From: Amanda Scholes on behalf of Planning.Responses
Sent: 03 January 2019 08:30
To: Planning Scanning
Subject: FW: Planning Consultation on: BR/311/18/PL
Attachments: Drainage - Supplementary Guidance Notes.pdf; Surface Water Drainage Submissions Checklist 191218.pdf

Engineers Comments Regarding Surface Water Drainage

APPLICATION **BR/311/18/PL**

Description of Works: Erection of 176 bedroom student accommodation building with associated hard & soft landscaping. This application may affect the setting of listed buildings, may affect the character & appearance of the Upper Bognor Road, Mead Lane Conservation Area & is a Departure from the Development Plan.

- SITE BOUNDARY
- EXISTING POTABLE WATER PIPE WITH EASEMENT
- EXISTING FOUL WATER PIPE WITH EASEMENT
- EXISTING CULVERTED WATERCOURSE

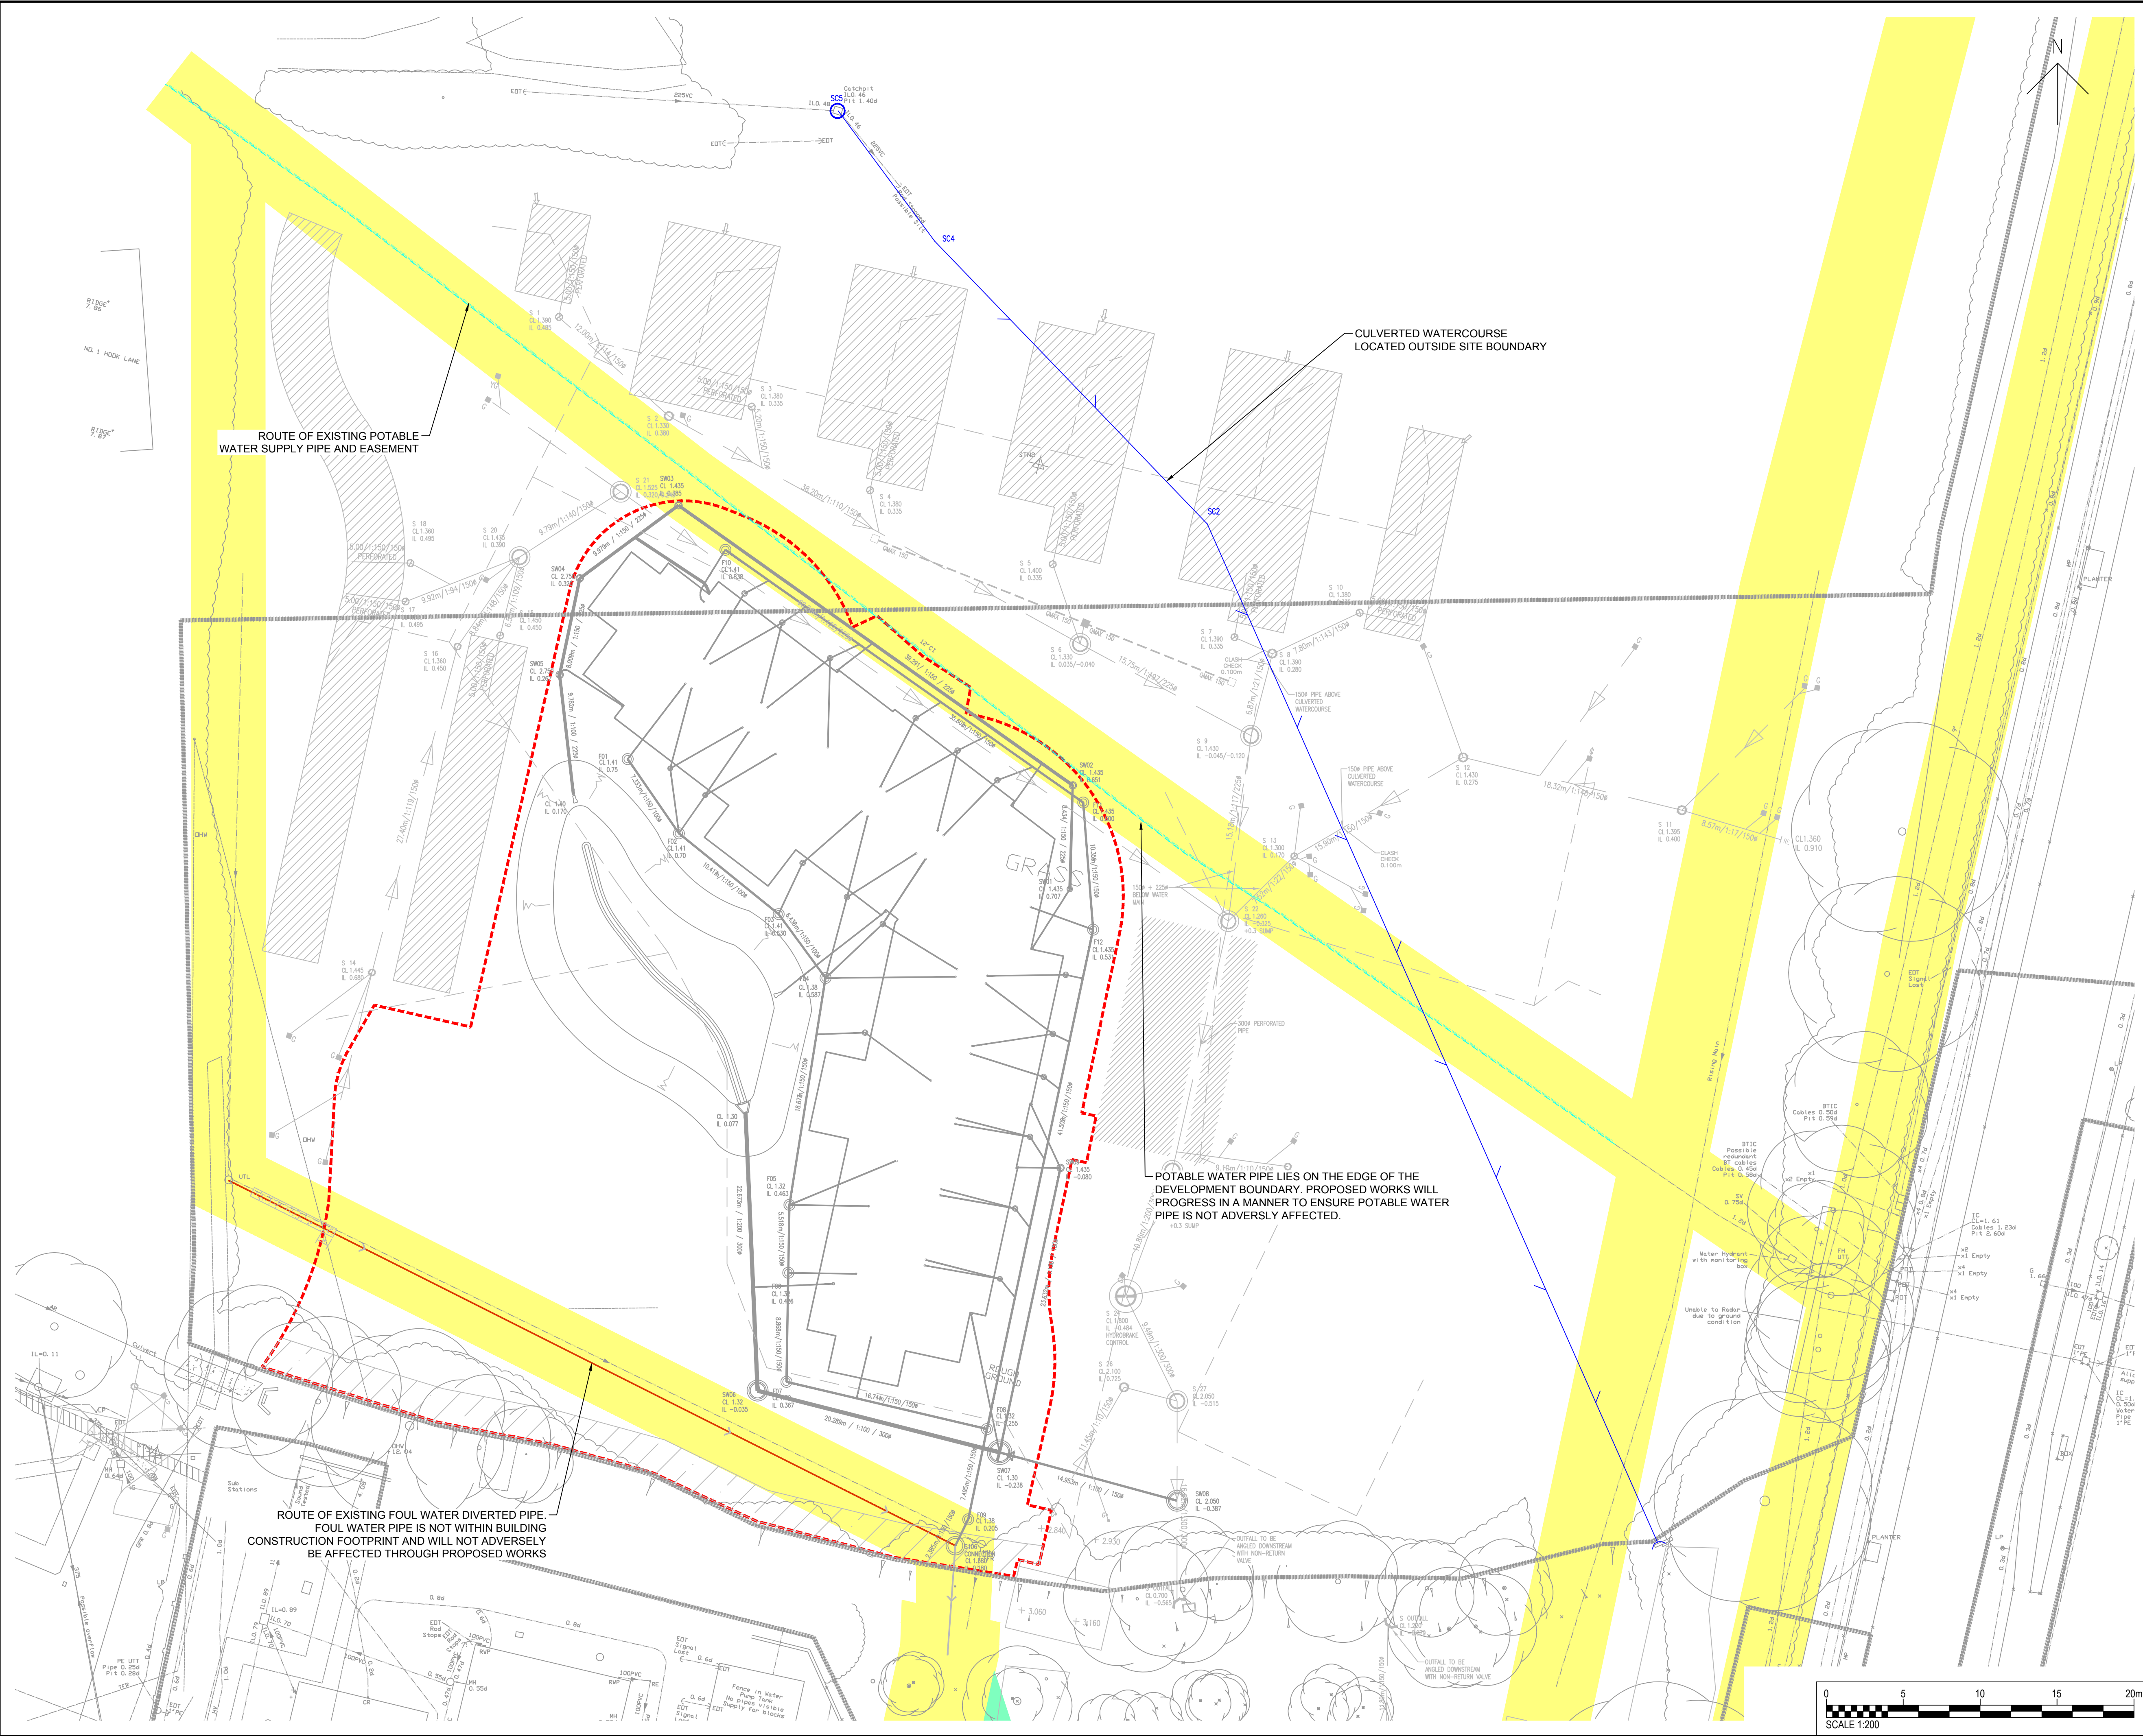
There is a private sewer running through the site which is in a poor state of repair. The applicant has been in consultation with us regarding this previously. The corrective measures identified must be undertaken. The derelict culvert that is also present in this area should be removed, the applicant is advised to contact us regarding this.
